Technical Note

Project	Goldthorpe - Air Quality Comments
Subject	Further Consultation Response
Project no	00052805
Date	14 August 2024

This Technical Note (TN) has been prepared by Vanguardia on behalf of Equite Newlands (Goldthorpe) Ltd (the applicant) to address further comments (Ricardo ref: ED18432127) received in respect to Air Quality works undertaken for planning Ref: 2023/1105 and a follow up meeting with Ricardo, Barnsley Metropolitan Borough Council (BMBC) and the applicant on 13th August 2024.

Figure 4 Doncaster Sheffield Meteorological Site Windrose (2022)

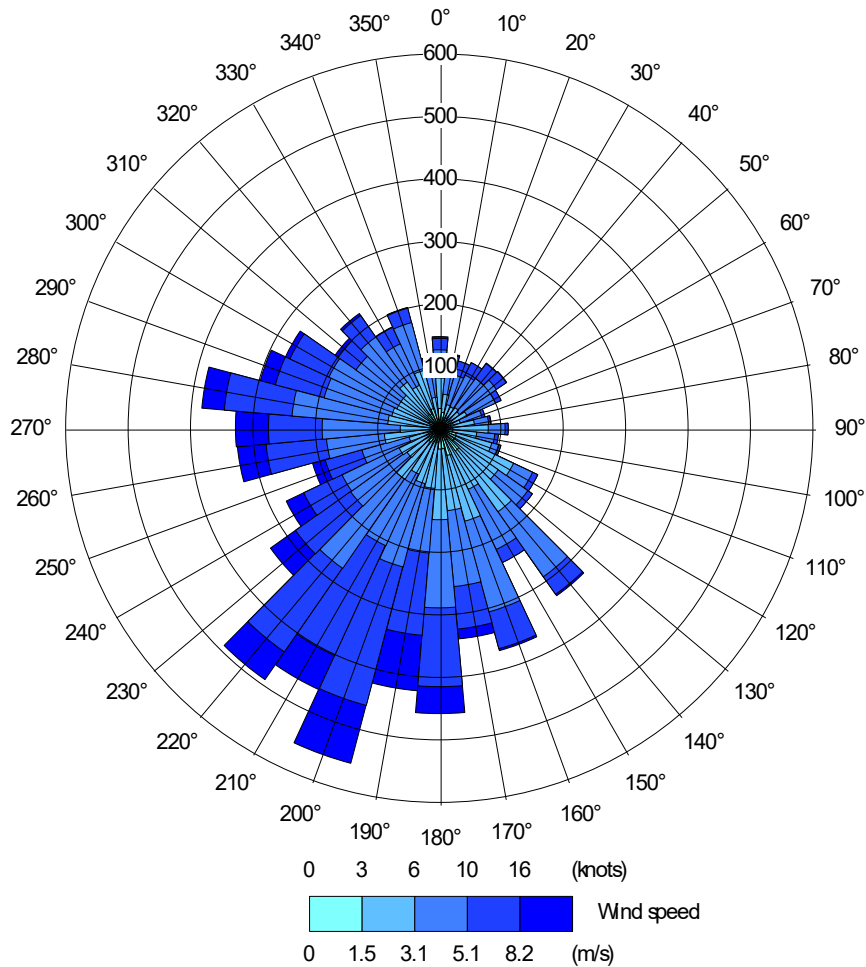
"Ricardo raised a query for the applicant to provide justification for using the meteorological site Doncaster Sheffield meteorological station. The applicant has now confirmed that although the Emley Moor meteorological station was most suitable, it was agreed with the EHO that Doncaster Sheffield should be utilized for the assessment scenario. An updated modelling has now been undertaken for 2023 using Emley Moor meteorological

station. However, no justification has still been provided on why the site is considered representative of the meteorological conditions at the dispersion site. The applicant should confirm the distance away from the site, the height above sea level and any other parameters that can help justify that the met site is representative of the dispersion site. We have reviewed the meteorological site location, and provided that data capture is sufficient we agree that this choice of meteorological site is sensible"

Emley Moor meteorological station is ~ 26.9 km from the dispersion site. The meteorological station is ~ 268 m above sea level. The data capture for the relevant parameters is between 92.8% and 93.6%. In line with Paragraph 7.523 of TG22, this sits above the minimum 85% required, and therefore it is deemed reasonable to assume this query is satisfied for both the applicant and BMBC sub-consultant.
